OUT19/7462

**Kemps Creek Warehouse, Logistics and Industrial Facilities Hub (SSD 9522)
Environmental Assessment**

EROSION AND SEDIMENT CONTROL PLAN - STAGE 2
SCALE 1:1500

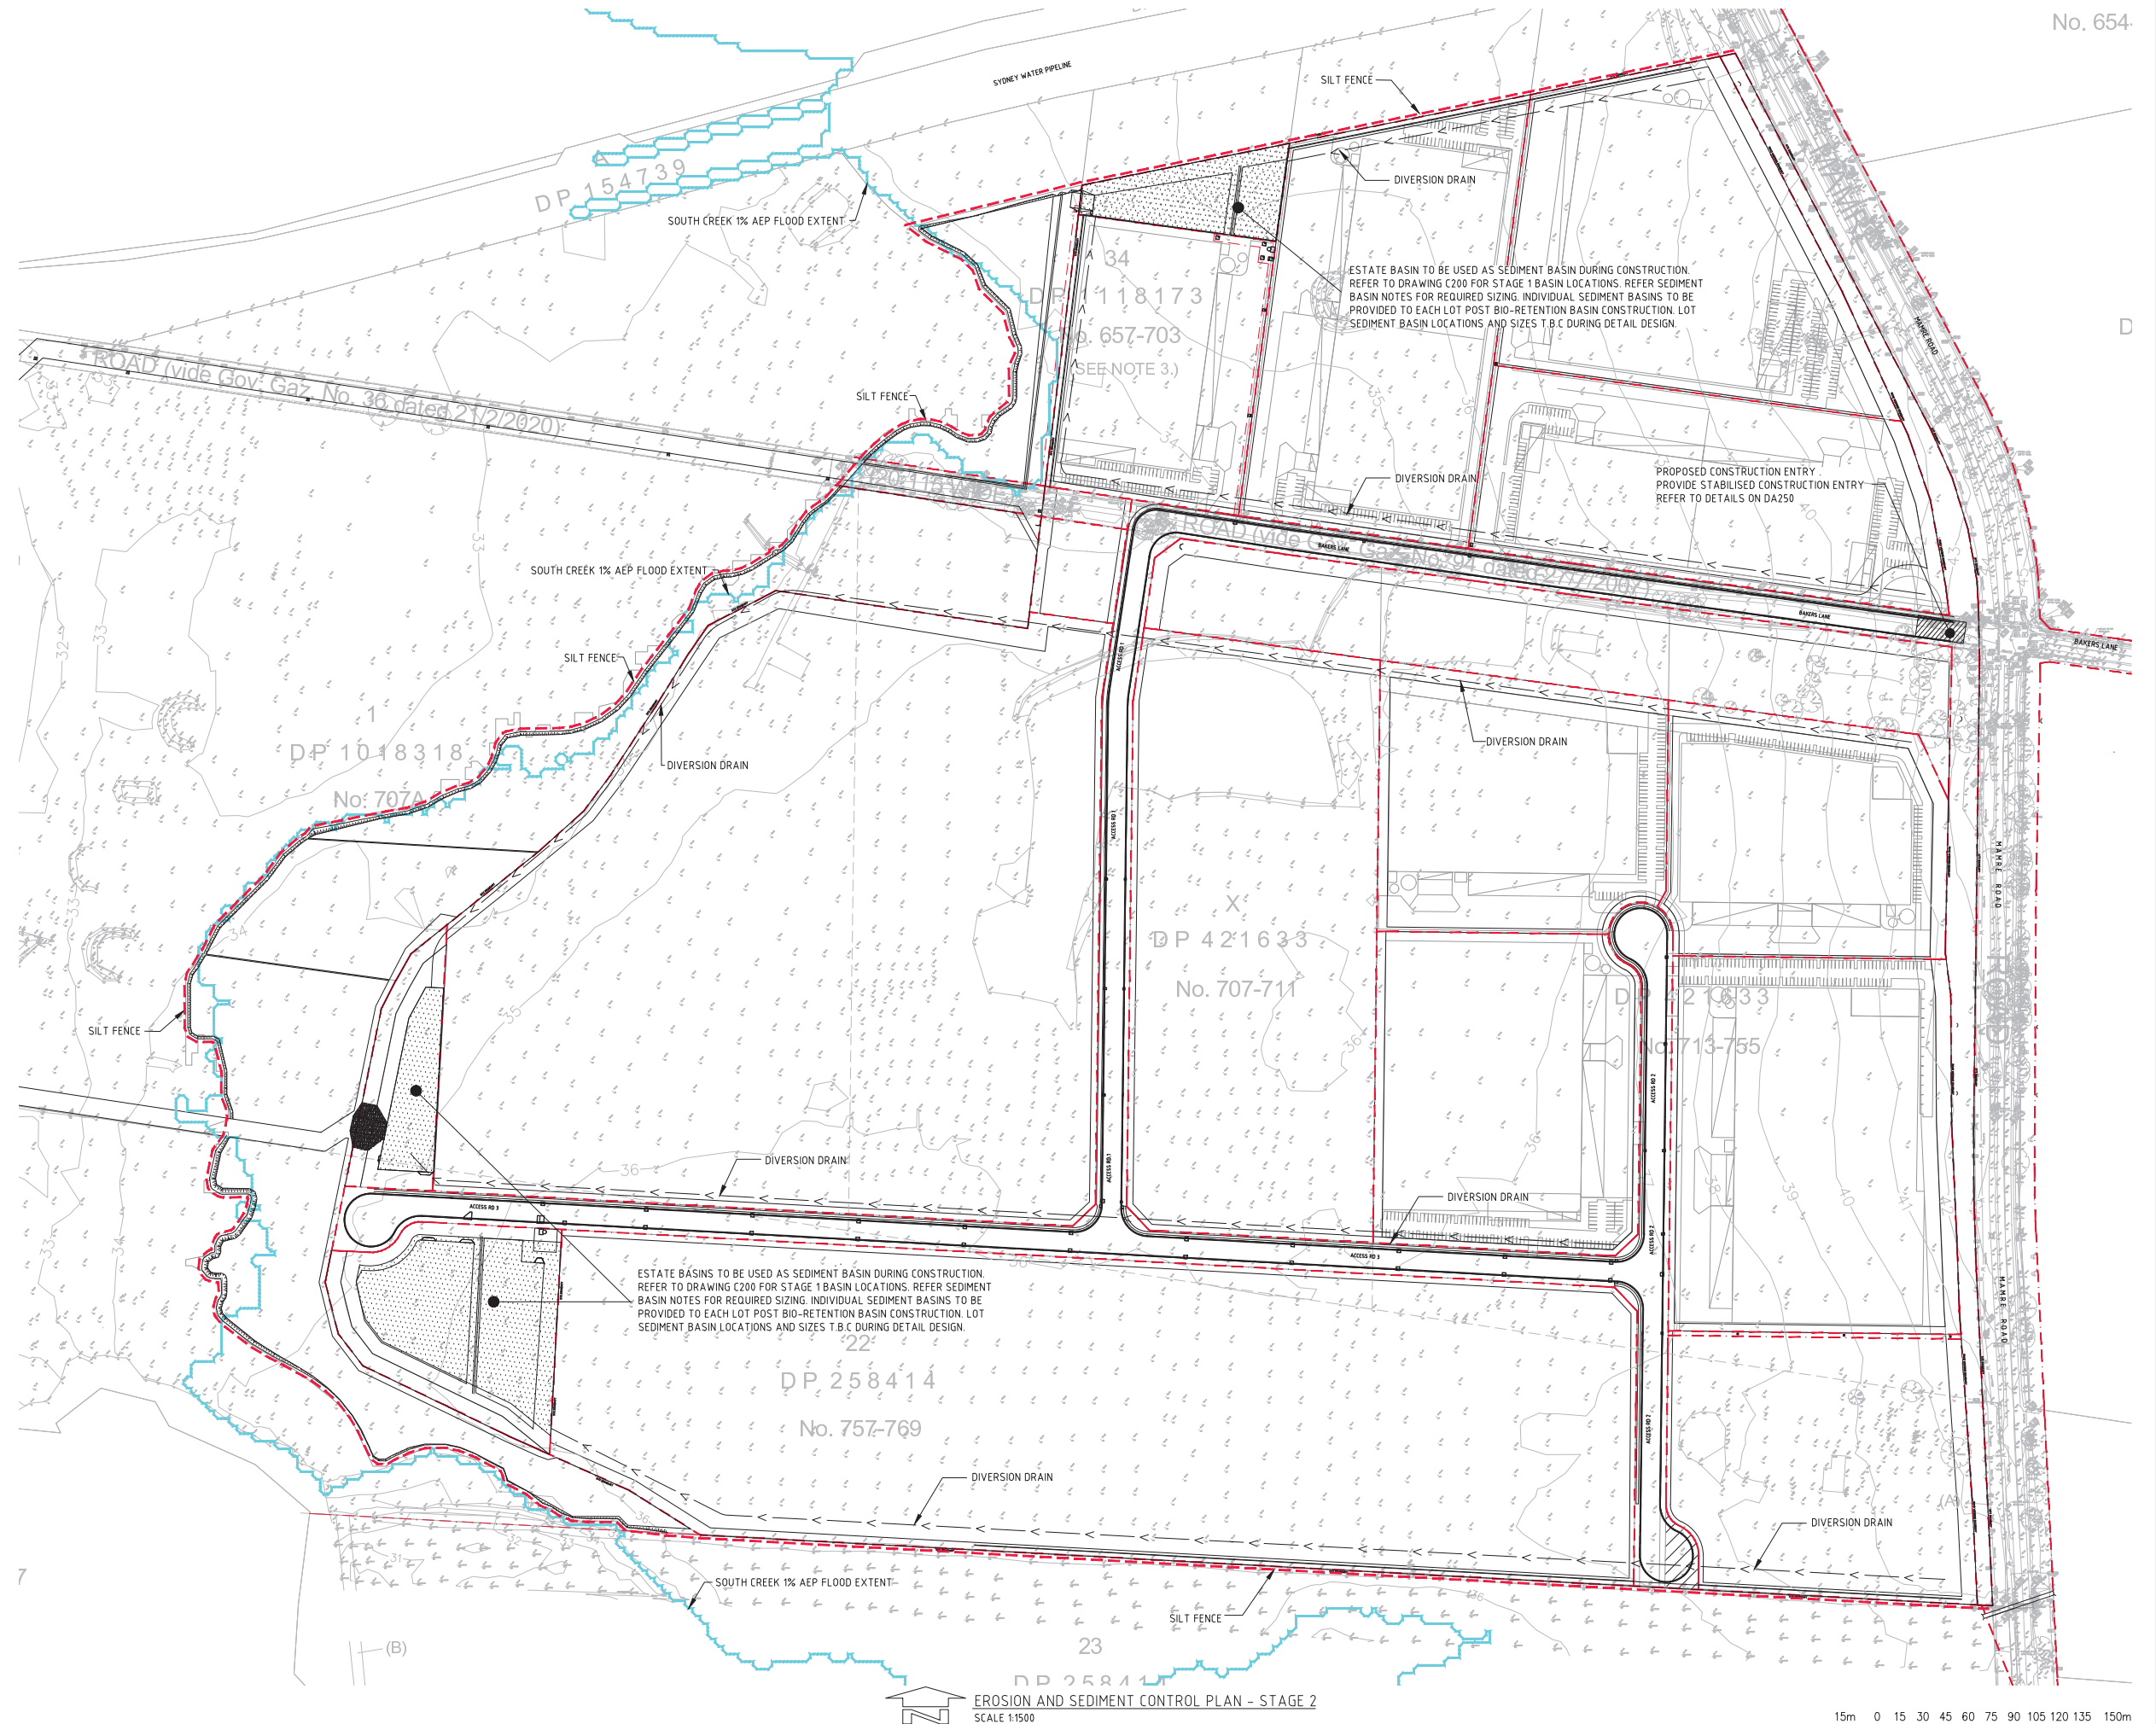
- Additional sediment controls are required along South Creek. Appendix 11 – Overland Flow Report proposes the installation of a single silt fence along the top of the bank of South Creek. Due to the scale of the earthworks at Kemps Creek, and recent increases in sediment input to South Creek from other construction sites, Fisheries recommends that three parallel silt fences be installed to protect South Creek from sediment runoff. This would involve.

1. One silt fence installed at the top of the bank,
 2. A second silt fence parallel and offset 10m from top of bank,
 3. A third silt fence parallel and offset 20m from top of bank.During short periods where work is required within 20m of the bank, these offsets may be reduced to 5m each.

- Any flows directed to South Creek, including water diversion drains must have erosion and sedimentation controls installed to ensure that sediment is not being transferred to the creek.
